**From:** Brenda Larsen  
**Sent:** Monday, January 07, 2013 9:29 AM  
**To:** Jeff Watson  
**Subject:** RE: BL-12-00031 Daugherty  
**Attachments:** Daugherty.doc

Re: Daugherty (BL-12-00031)

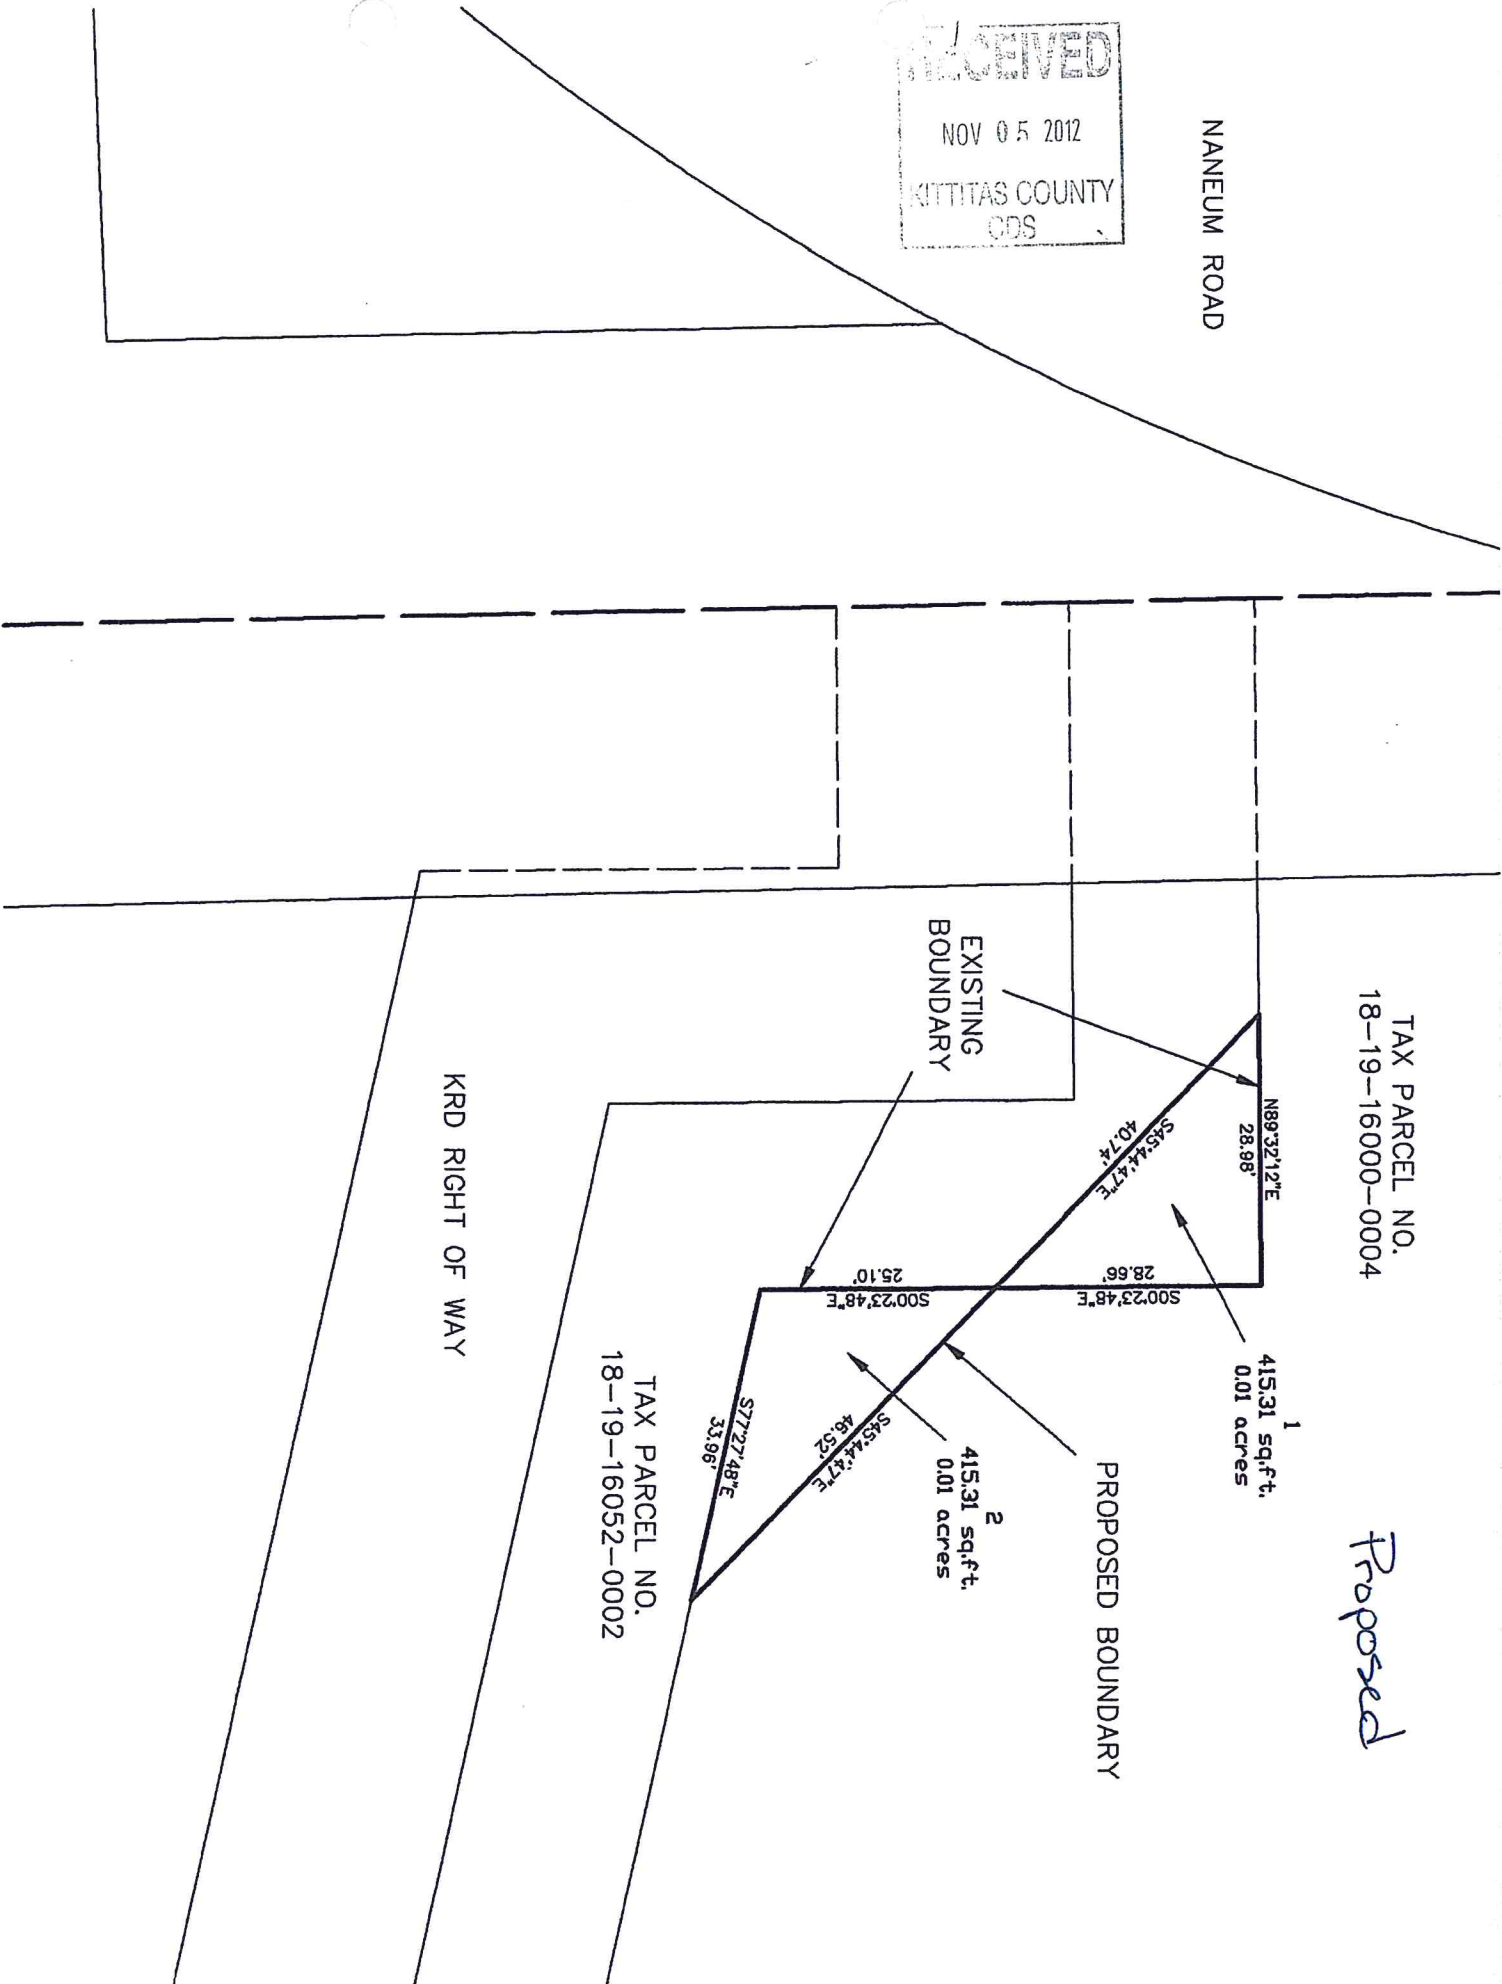
- Ensure that boundary line adjustments do not infringe upon existing structures, to include propane tanks, etc.
- All future development must comply with the International Fire Code.
